Consultant Advice

To: Claudine Malanum, Level 33 Development Manager		Date: 23/02/2026		
Company: Wollongong Development No.8 Pty Ltd		Consultant Advice No: 001		
Email: claudine@level33.com.au		File/Ref No: Crown Square-Consultant Advice- Rev A		
Subject: Crown Square Consultant Advice regarding items flagged by Wollongong City Council.		Project Address: Crown Square, Wollongong, NSW 2500		
Issued by: Jed Hugill				
Distribution:				
To:	Cc:	Company:	Person:	Email:
☒	☐	Level 33	Claudine Malanum	claudine@level33.com.au
☐	☐			
☐	☐

2.0 Wollongong City Council's Flagged Items for Lote Consulting Review

Figure 8-2- Atchinson Street East to West Link

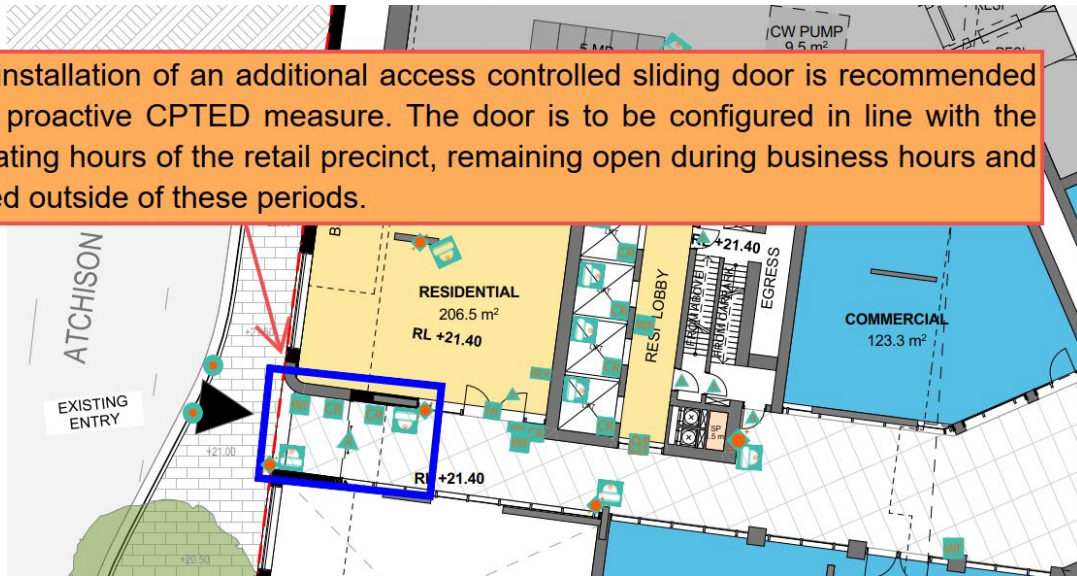
3)	Design Excellence	The corridor entry configuration at the Atchison Street frontage is not supported due to CPTED concerns. It leads to commercial space that would likely be closed in the evening or difficult to tenant. This corridor space would be better occupied by a more generous residential lobby area similar to that approved under DA-2021/957 with a controlled entry point at Atchison Street.

The corridor entry configuration at the Atchison Street frontage has been reviewed in response to the CPTED concerns raised. The current arrangement provides a transitional space between the street interface and internal areas; however, such corridors can experience reduced activation outside of business hours where adjoining commercial tenancies are closed or underutilised. This condition may limit passive surveillance and reduce informal oversight during evening periods.

The alternative approach suggested, involving an extension of the residential lobby to occupy this frontage, presents several CPTED advantages. A larger residential lobby with a controlled entry point would support stronger access control, improve territorial definition, and reduce the potential for spaces that could be misused for unintended activities. From a crime prevention perspective, this approach strengthens first and second generation CPTED outcomes by consolidating entry points and clarifying public and private domains.

Should the design be amended in this manner, no adverse security implications are identified. The proposal would instead enhance control, visibility and defensible space, provided appropriate access control, lighting and surveillance measures are integrated into the lobby design.
